Re: Planning Application 20/1016

Address: Longsight House Longsight Road Copster Green BB1 9EU

Description: Proposed two storey extension to side and rear of property with basement extension to form additional living accommodation.

Simon Hardie
Highways Development Control
Lancashire County Council

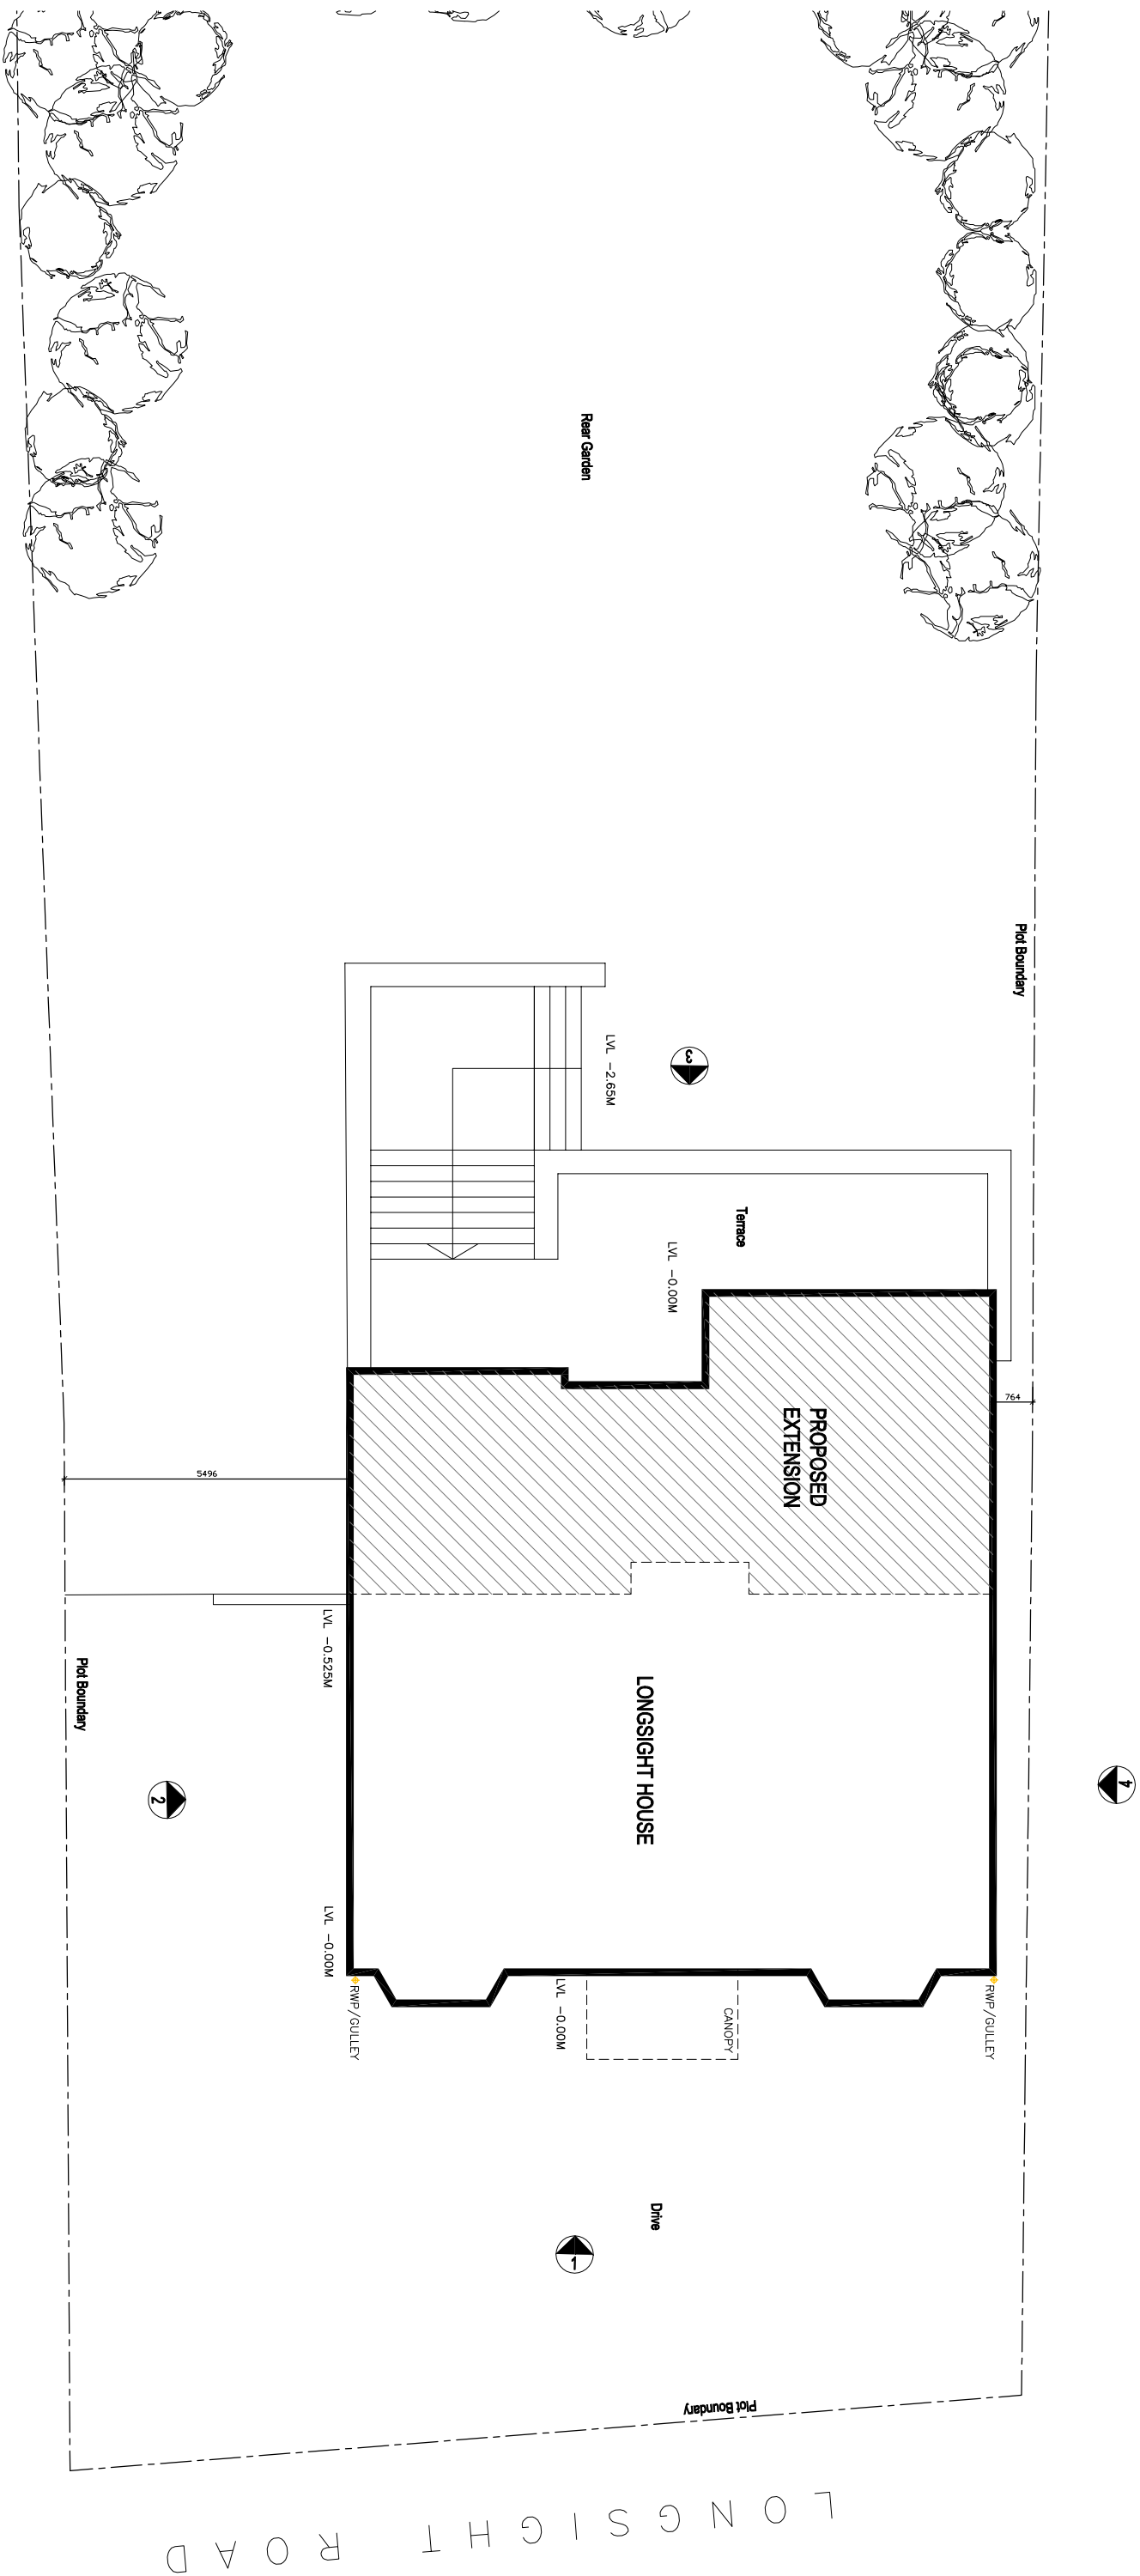
1. Before the access is used for vehicular purposes, that part of the access extending from the highway boundary for a minimum distance of 5m into the site shall be appropriately paved in tarmacadam, concrete, block pavements, or other hard material to be approved by the Local Planning Authority.
Reason: To prevent loose surface material from being carried on to the public highway thus causing a potential source of danger to road users.
